ADDRESS:  
12260 SMITH ROAD  
DESCRIPTION:  
FALCON RANCHES  
LOT 7 BLOCK 1 SUB 1  
EL PASO COUNTY, CO

Please add:  
PCD  
File No.  
VA266

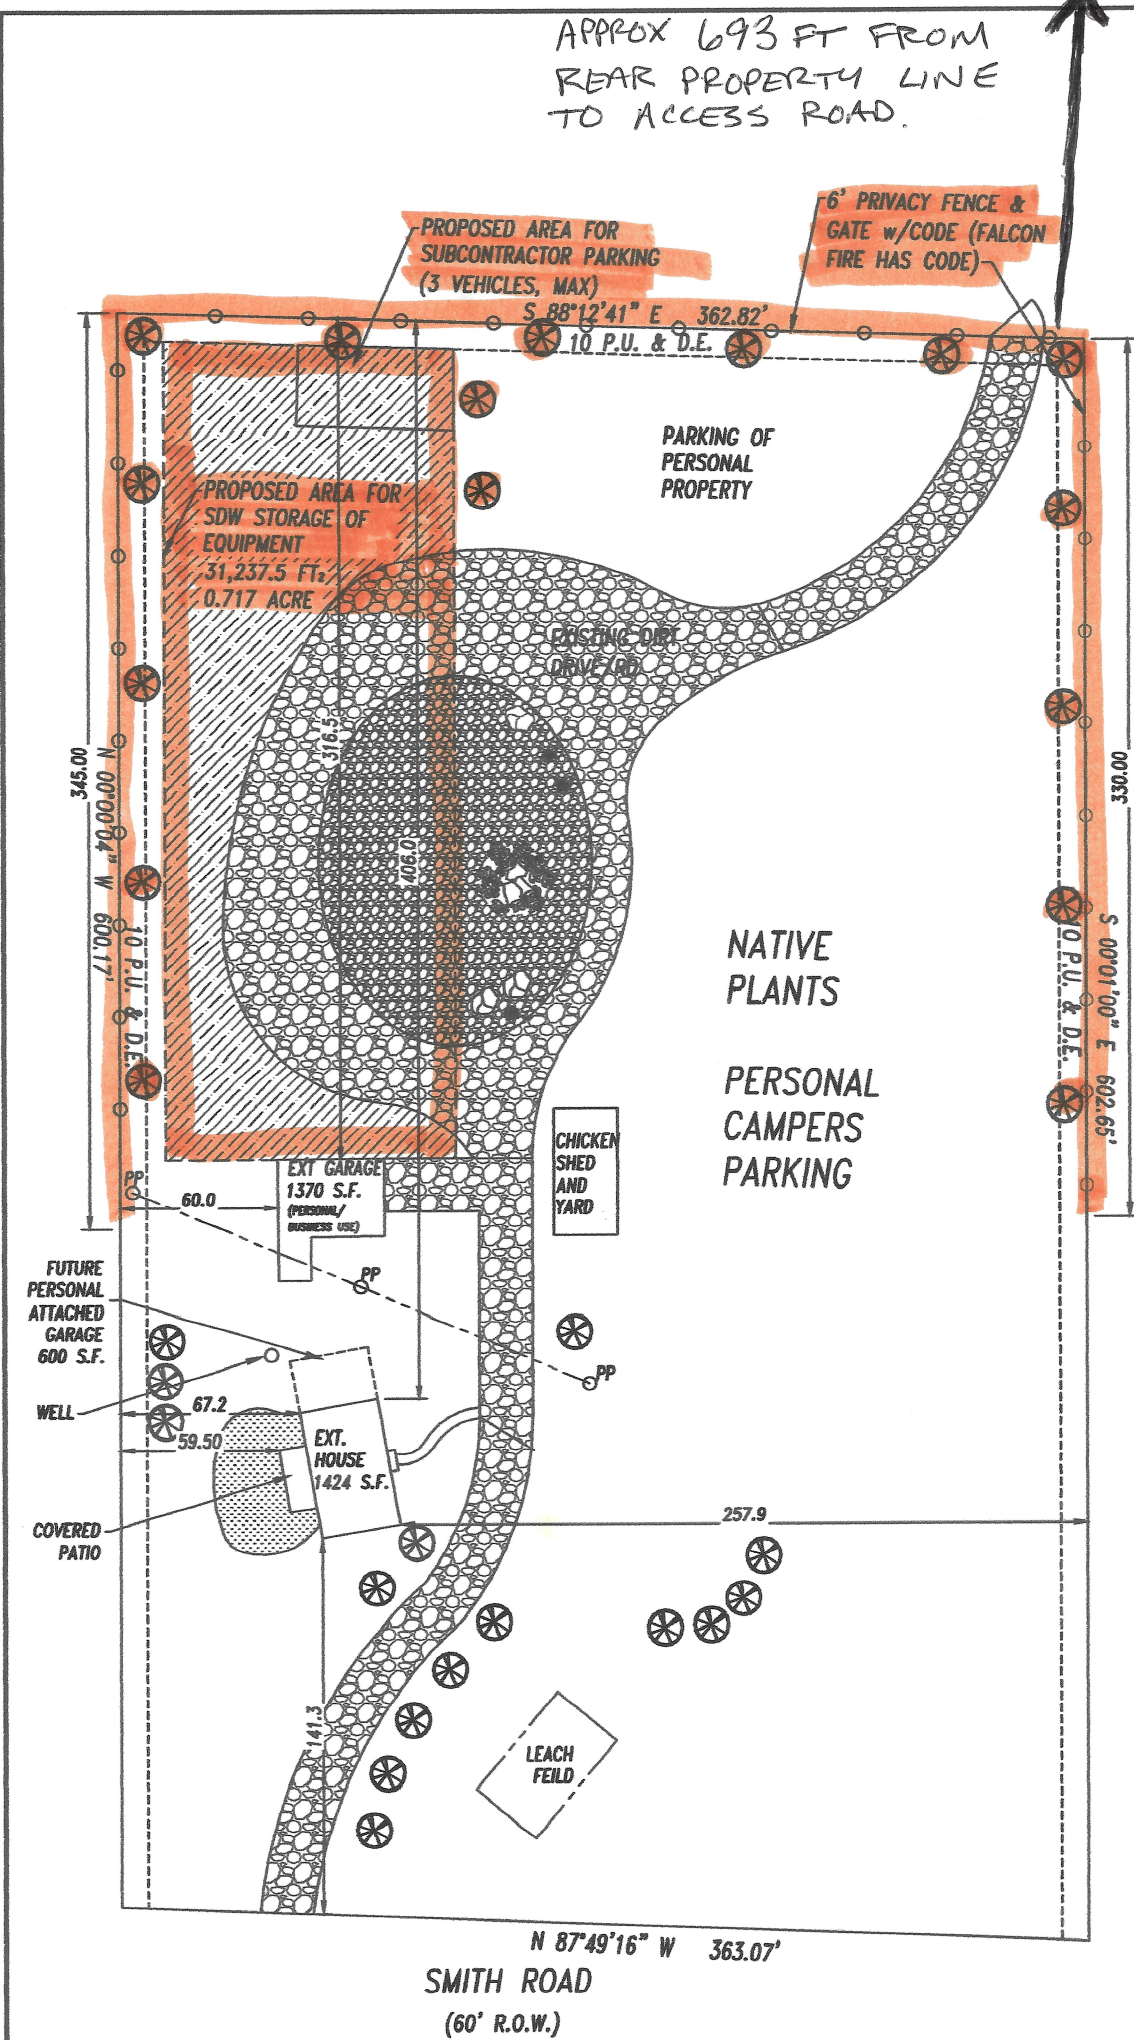
Please show proposed parking spaces.

No Storage in Required Landscape Area. Outside storage shall not be allowed within any required landscaped area.

Note: Recommend reducing the proposed area for outdoor storage. With RFI for outdoor storage \$447/1,000 sf, RFI will be just under \$14,000 for 31,237.5 sf.

Storage of Equipment and Vehicles Exceeding Height of Fence. All equipment and vehicles exceeding the height of the fence shall be stored on the rear 1/3 of the property except when adjacent to a residential zoning district, in which case the equipment or vehicles shall be a minimum 50 feet from the residential zoning district boundary.

Specific the surface proposed for the subcontractor parking. Gravel? Paved?

Please show vehicle circulation.

existing?

Note: There is no Driveway Access Permit on file for the parcel. A driveway access permit is required for all access points onto a county or private road. Please apply for driveway access permits through EDARP.

Label width of driveway access at right-of-way for all accesses.  
ECM 2.4.1.E, Two-Way Commercial or Industrial Points. Two-way commercial or industrial parcel access points shall have:  
\*For nonresidential collector and local roadways: a minimum 25-foot and maximum 40-foot access width.

Add note stating: The owner agrees on behalf of him/herself and any developer or builder successors and assignees that Subdivider and/or said successors and assigns shall be required to pay traffic impact fees in accordance with the El Paso County Road Impact Fee Program Resolution (Resolution No. 25-337), or any amendments thereto, at or prior to the time of building permit submittals. The fee obligation, if not paid at final plat recording, shall be documented on all sales documents and on plat notes to ensure that a title search would find the fee obligation before sale of the property.
